RE: 828 RIVERSIDE STREET

Enclosed are revised plans for the Riverside Street project. They have been modified in response to the November 24 memo from Woodard and Curran. We have made the following revisions:

5 STABILIZED CONSTRUCTION ENTRANCE DETAIL

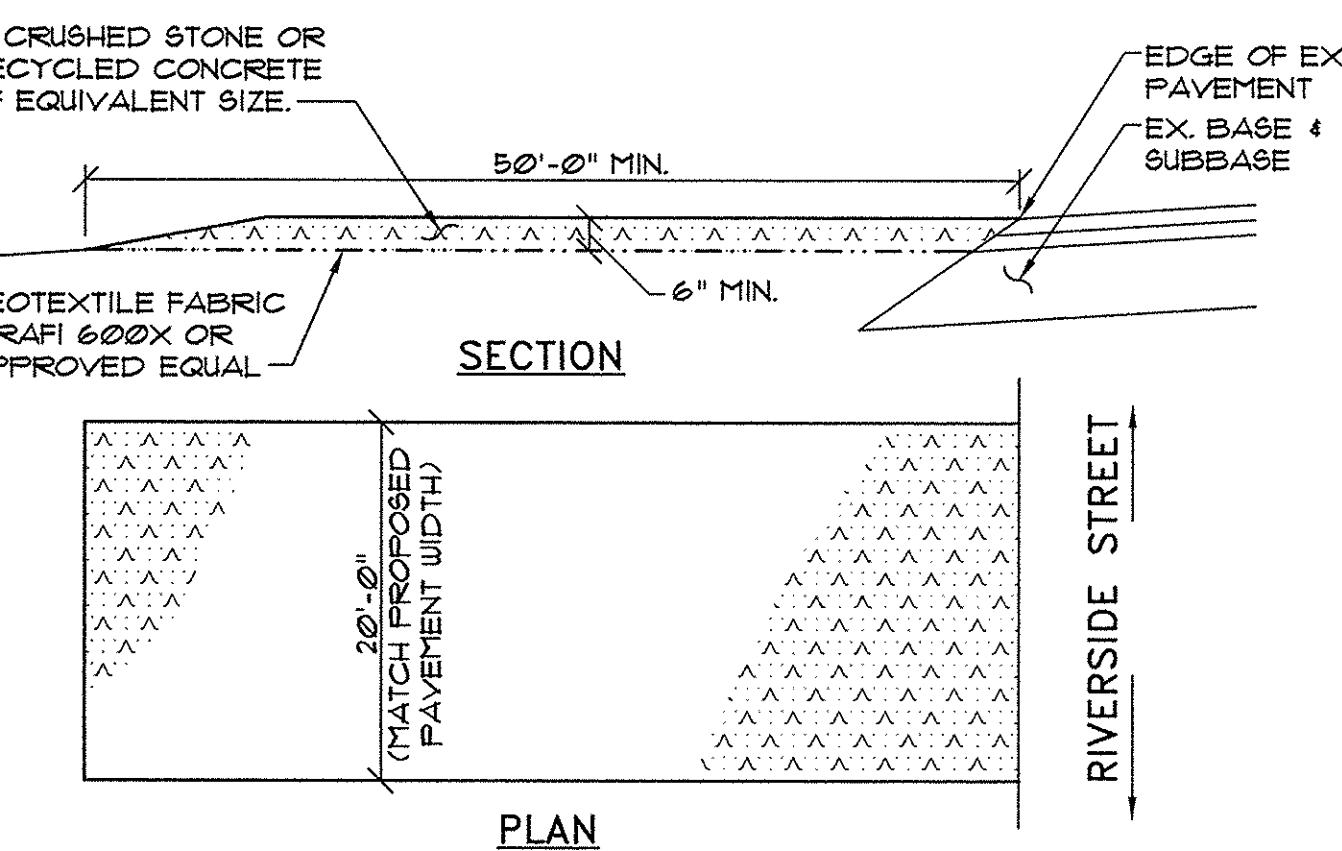
1. We have added the location and detail for a stabilized construction entrance.
2. We have corrected the error in the drainage calculations, and modified the size of the filter. The 6,000 sq. ft. should have been 600 sq. ft.
3. We have added the inspection and reporting requirements to the Maintenance Plan from Chapter 32 of the Ordinance.
4. We have added Figure II-12 to the drawings.
5. We have added a field inlet above the filter to bypass water from our neighbor's lawn.
